# CITY OF ALBUQUERQUE

December 2, 2022

**Re: Children's Grief Center**  
**4125 Carlisle Blvd. NE**  
**30-Day Temporary Certificate of Occupancy**  
**Transportation Development Final Inspection**  
Architect's Stamp dated 4-13-21 (G16-D157)  
Certification dated 10-25-22

B1 SITE PLAN
1" = 20'-0"

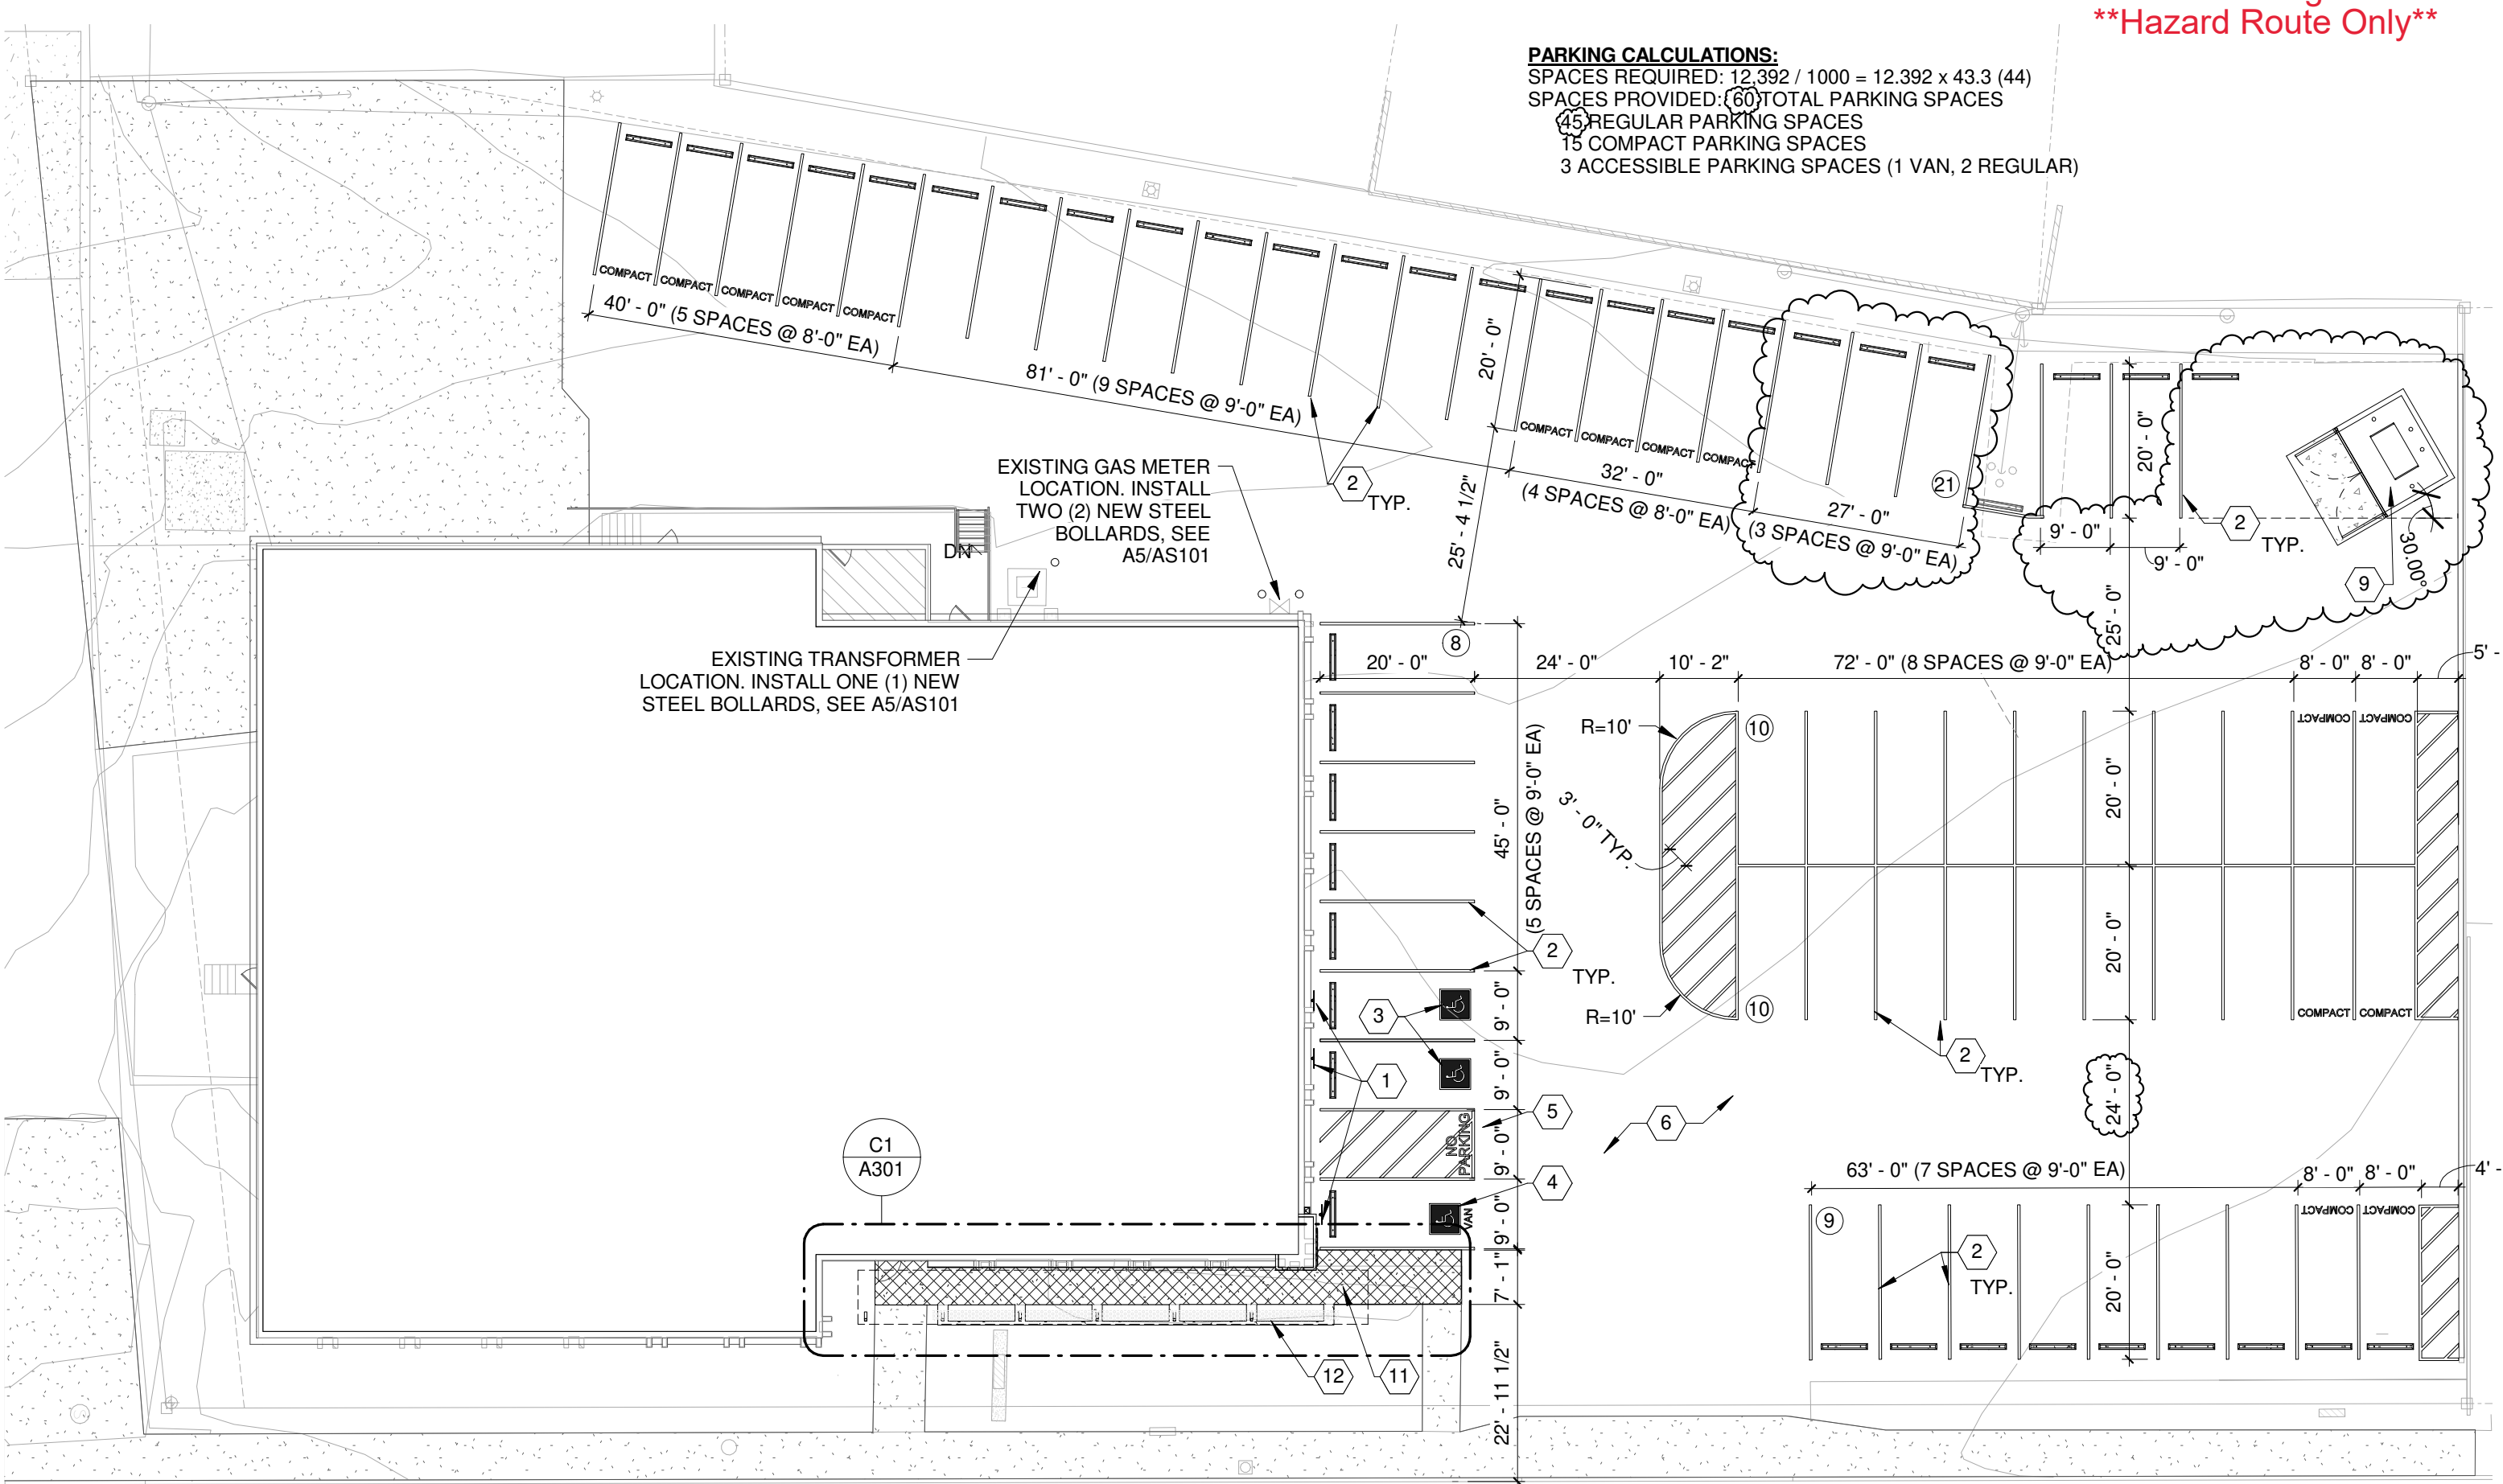
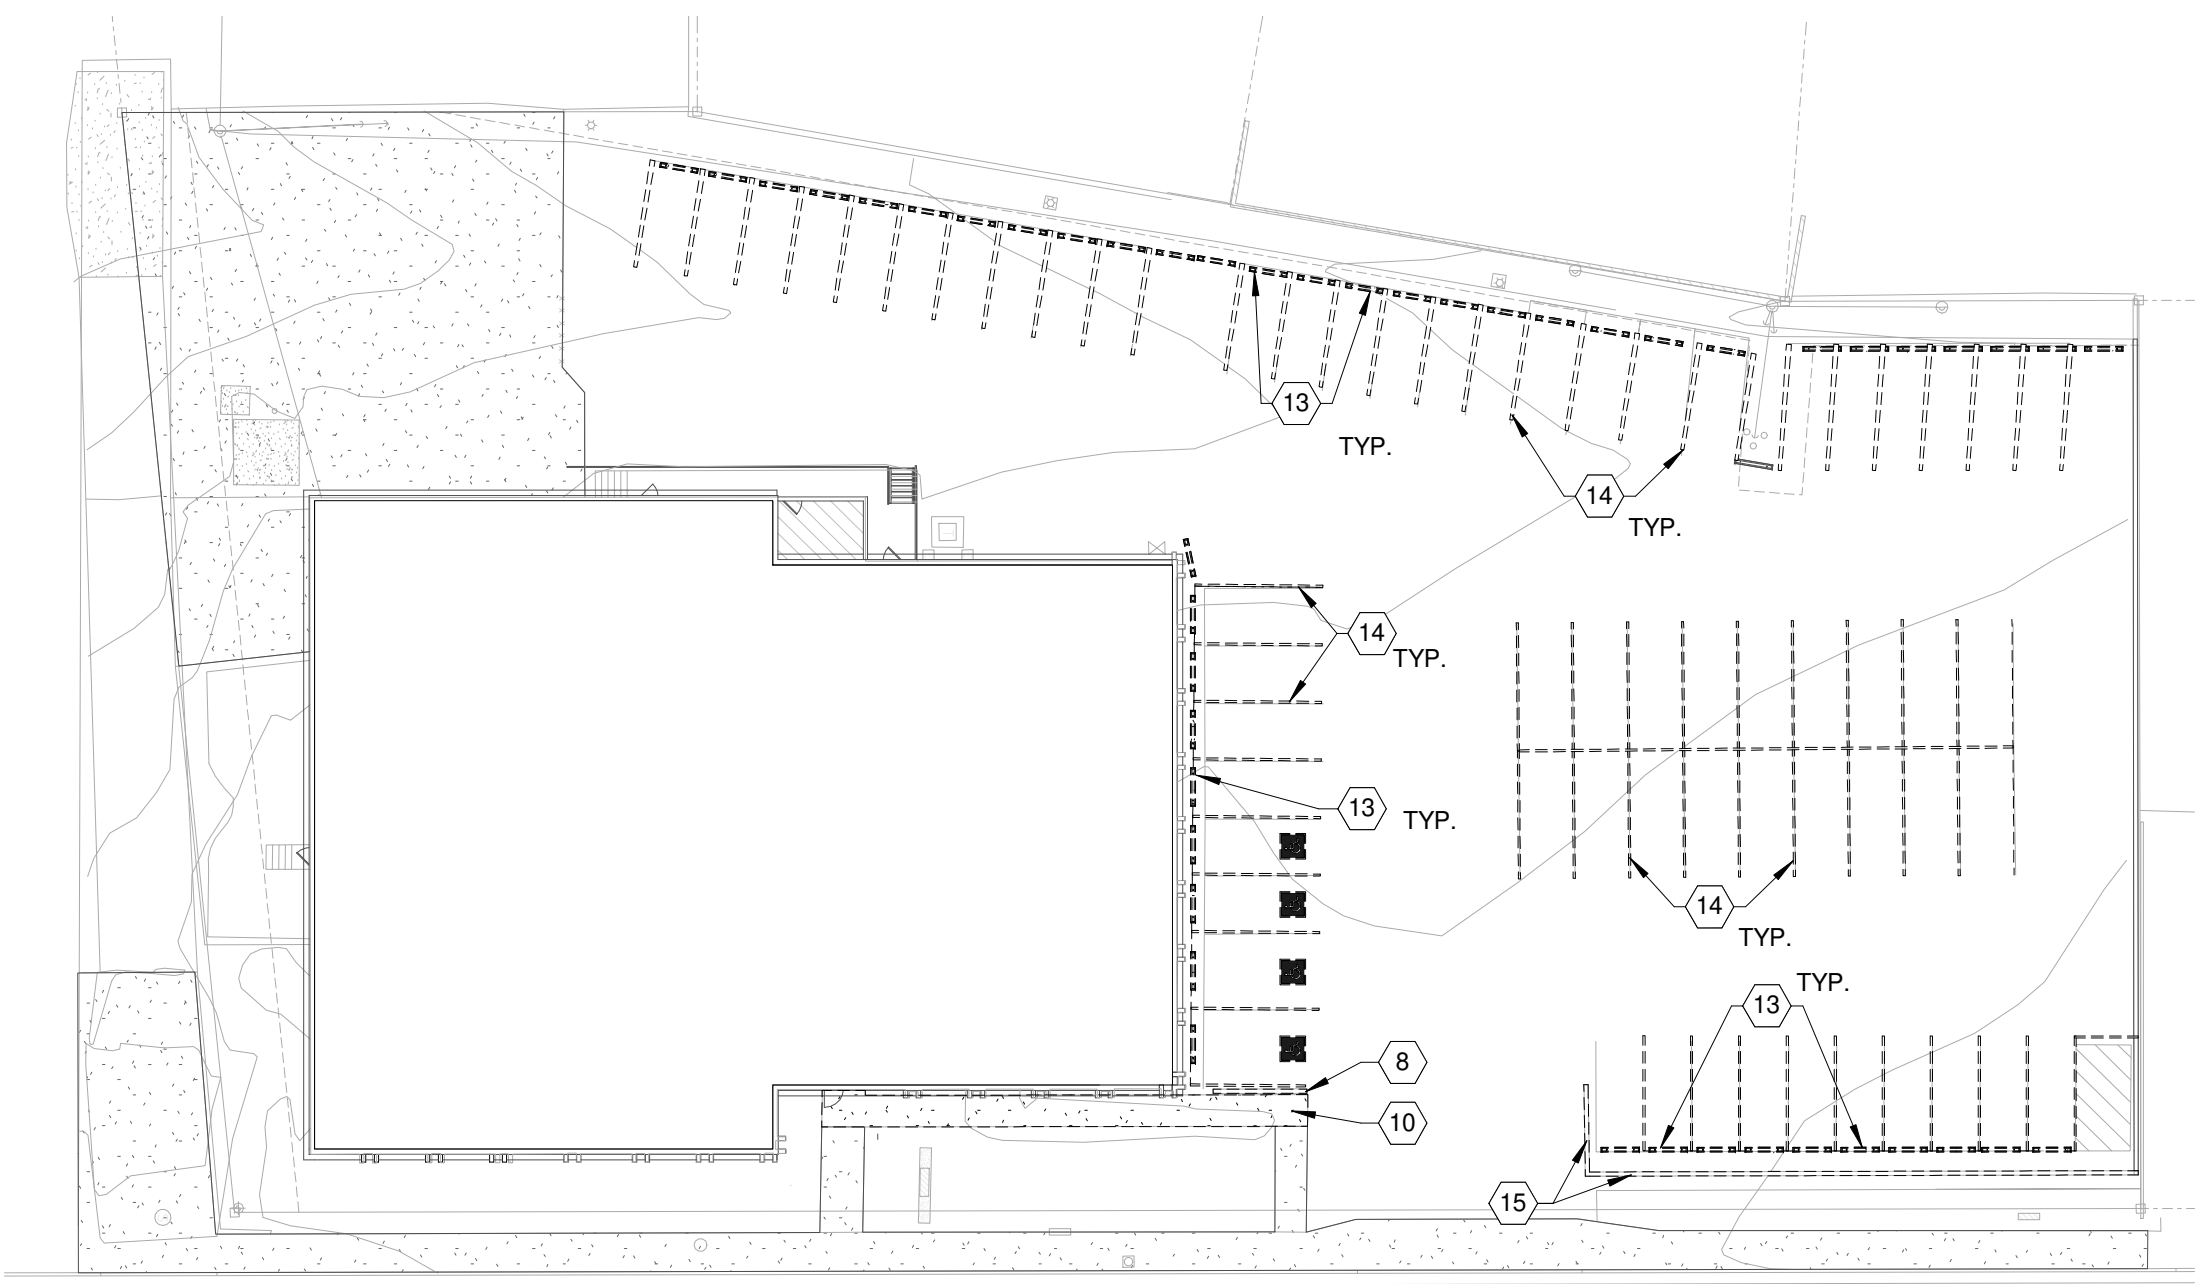
- Please update the ADA signage to the current standard. The ADA accessible parking sign must have the required language per 66-7-352.4C NMSA 1978 "**Violators Are Subject to a Fine and/or Towing.**" Please call out detail and location of signs.
- Provide Motorcycles' parking spaces signs.
- Provide a copy of approved COA easement.
